Planning Consultation Request
Town and Country Planning Act 1990
APPLICATION FOR PERMISSION TO DEVELOP LAND

Application No.	2025/90578
Proposed Development:	Change of use and internal alterations of first, second and third floors to form 5 apartments (Listed Building within a Conservation Area)
Location:	Prudential House, 69, New Street, Huddersfield, HD1 2BQ
OS Map Reference	SE 414441.5748 416469.8781
Applicant/Agent:	Northern Design Partnership
Class:	Minor Developments
Site Area (sq. m):	180.0

**Consultation Response from KC,
Conservation & Design**

**Change of use and internal alterations of first, second and third floors to form 5 apartments
(Listed Building within a Conservation Area)**

client	HD CENTRAL		
project	CHANGE OF USE OP UPPER FLOORS INTO APARTMENTS 69-71 NEW STREET HUDDERSFIELD HD1 2BQ		
drawing	EXISTING PLANS (WITH APPENDIX PHOTOGRAPH REFERENCES)		
revision	notes	date	drawn
*	*	*	*
scale :	1:100 AT A1	10.24	MG
project no.	drawing no.	revision	
2388	01

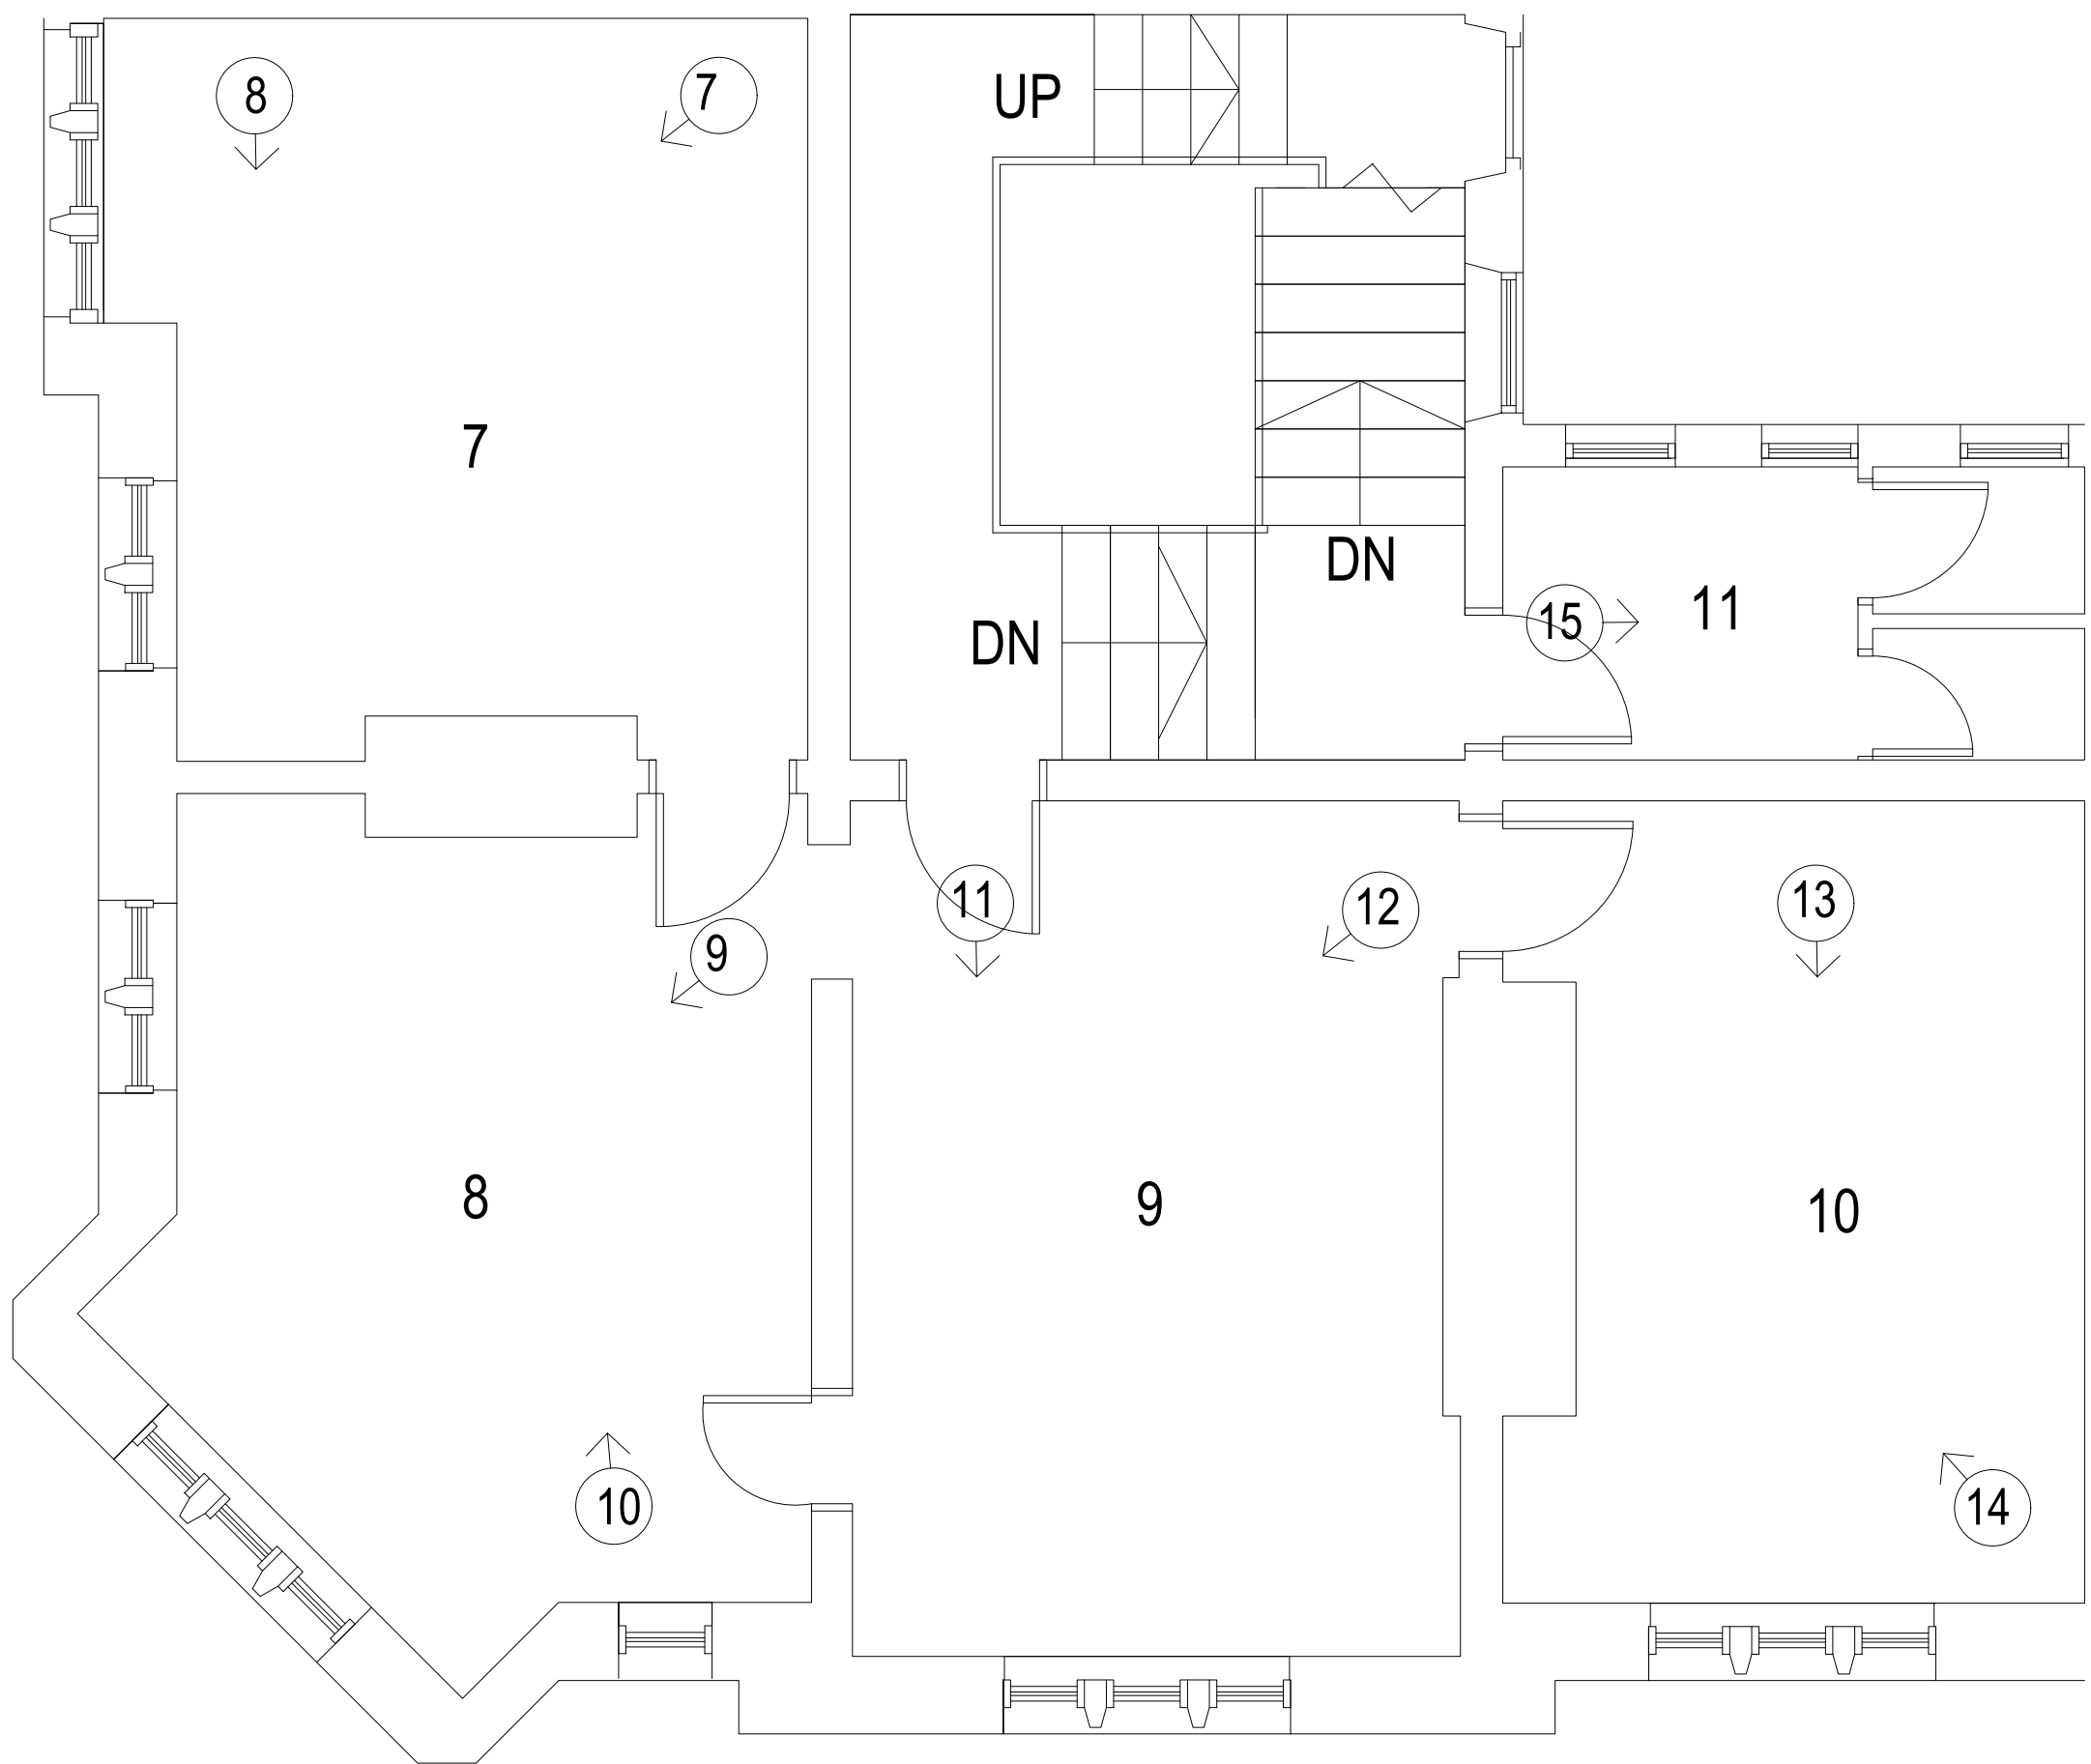
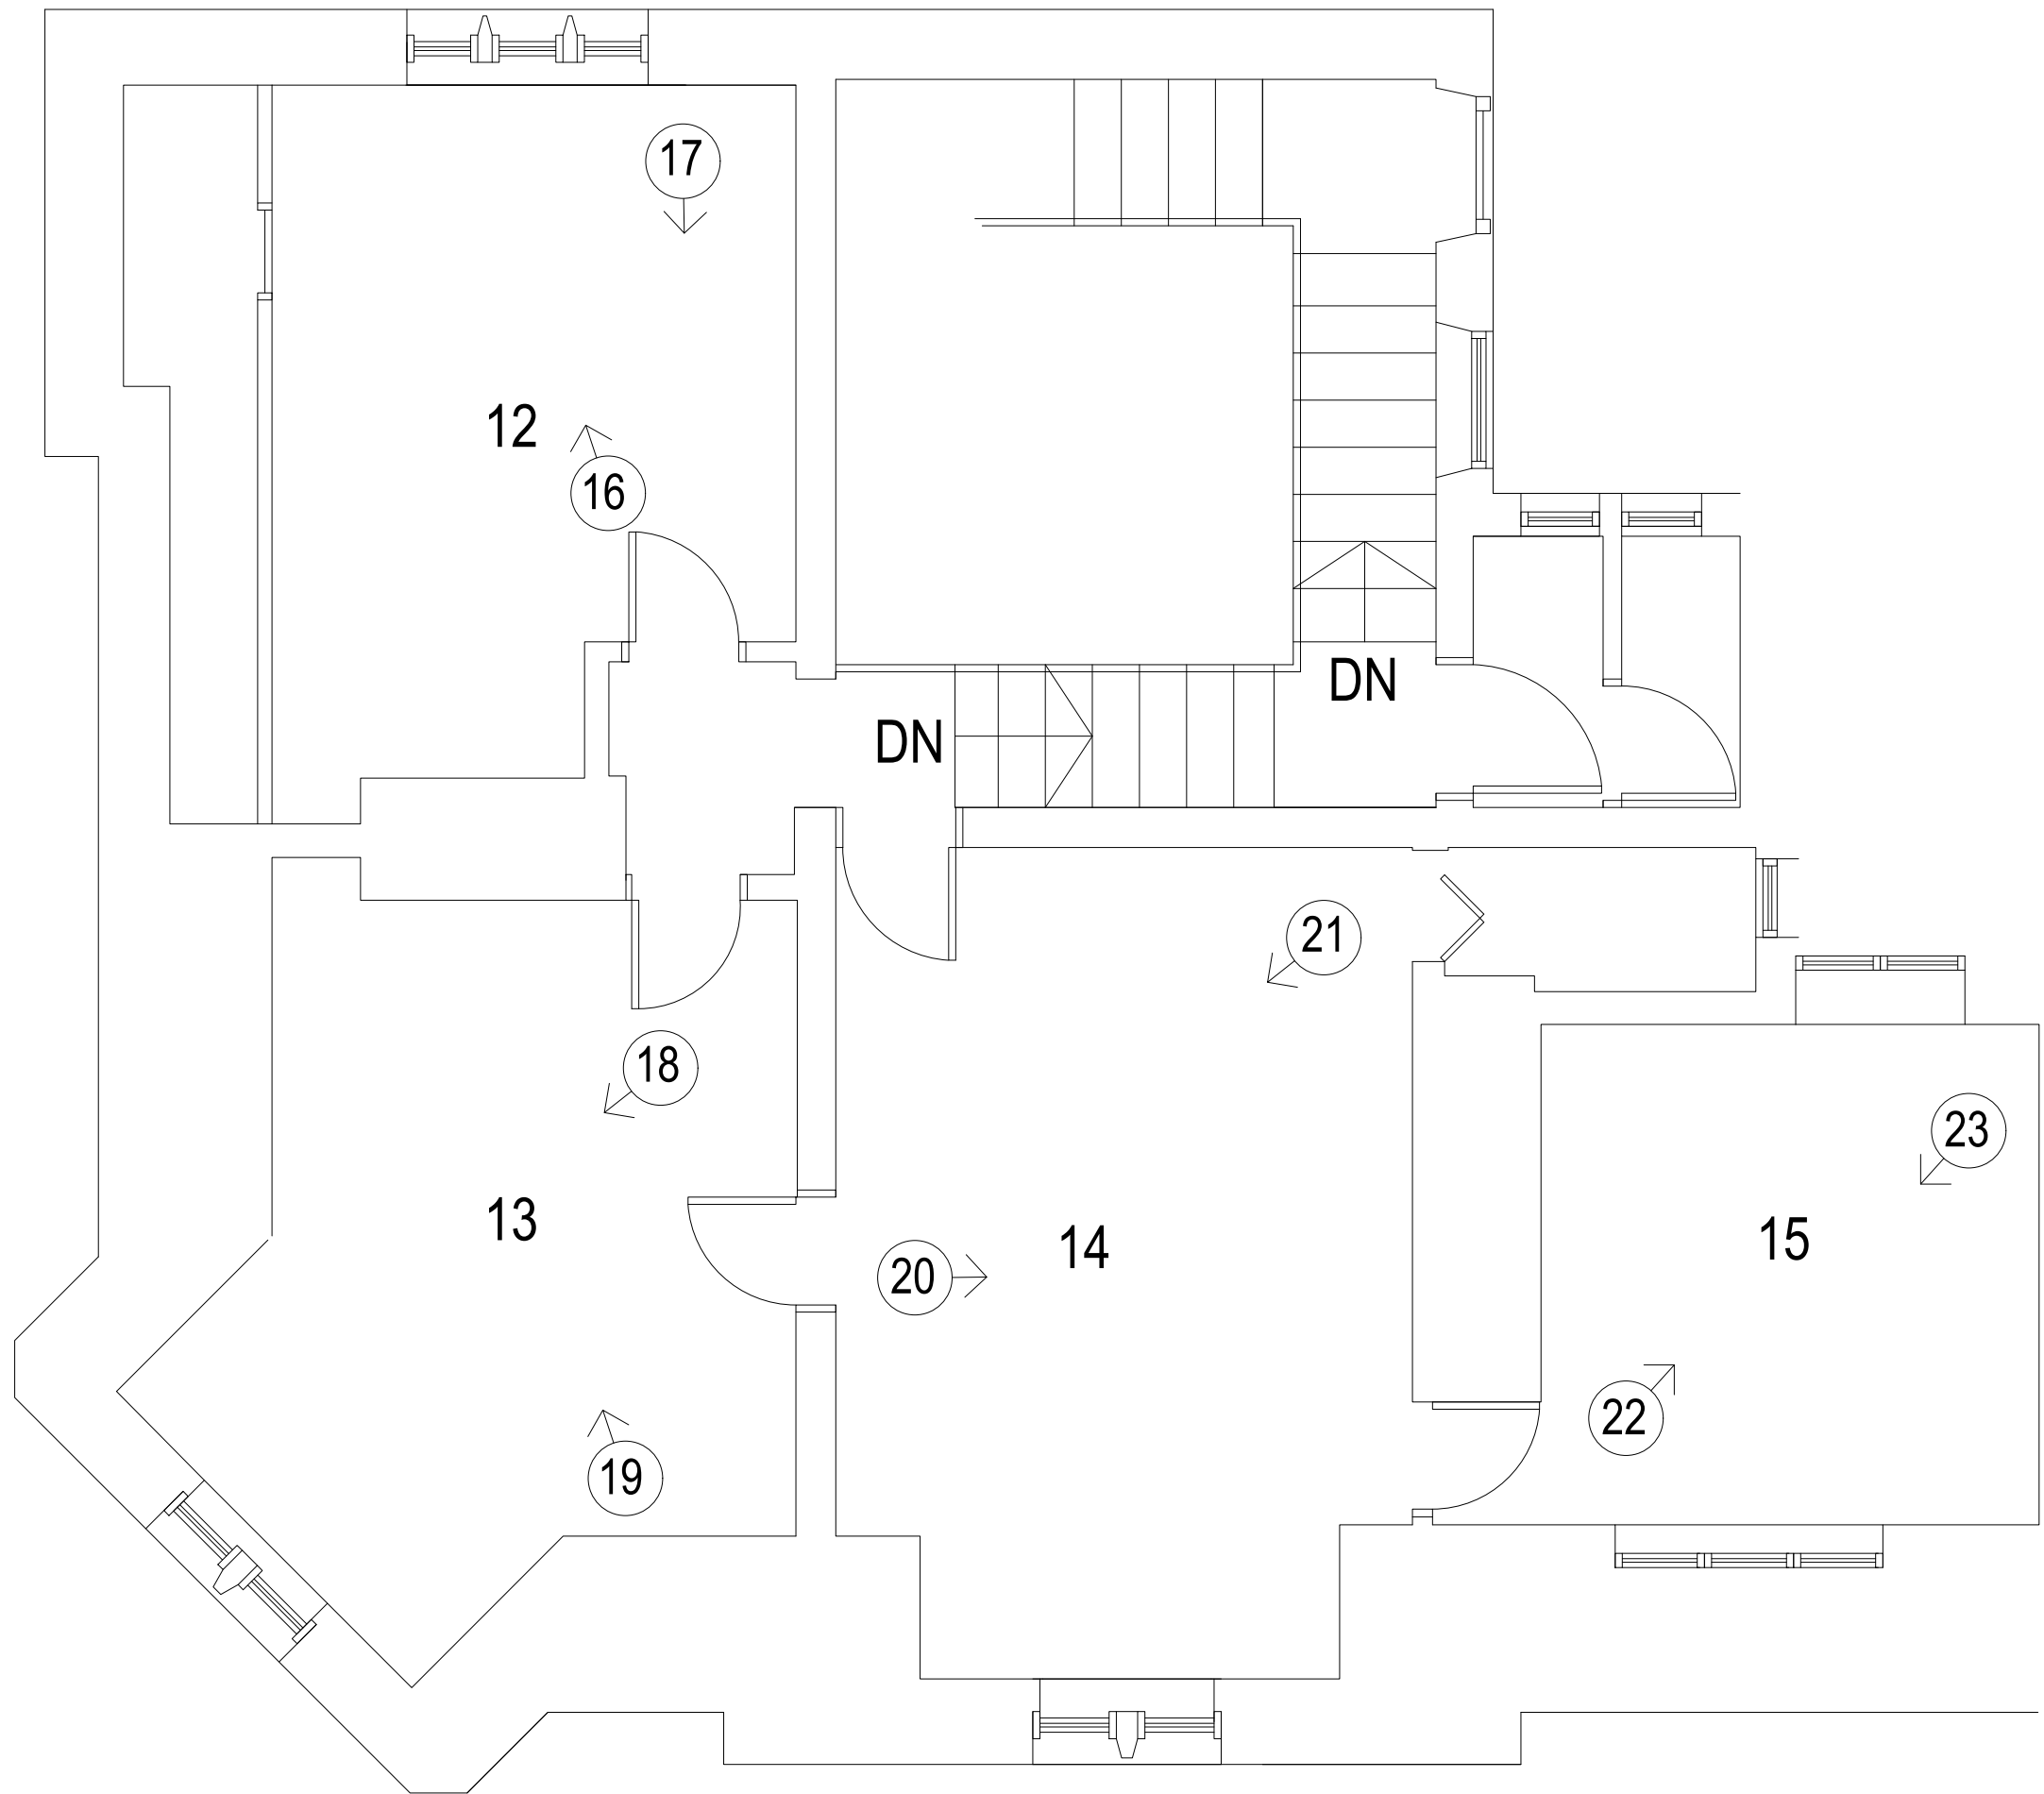
No works appear to be proposed to the staircases and the agent states that plans for the third floor indicate the fireplaces will be retained.

Where deep cornices, picture rail, deep skirting and window surrounds including areas of panelling below remain, this should be retained wherever possible.
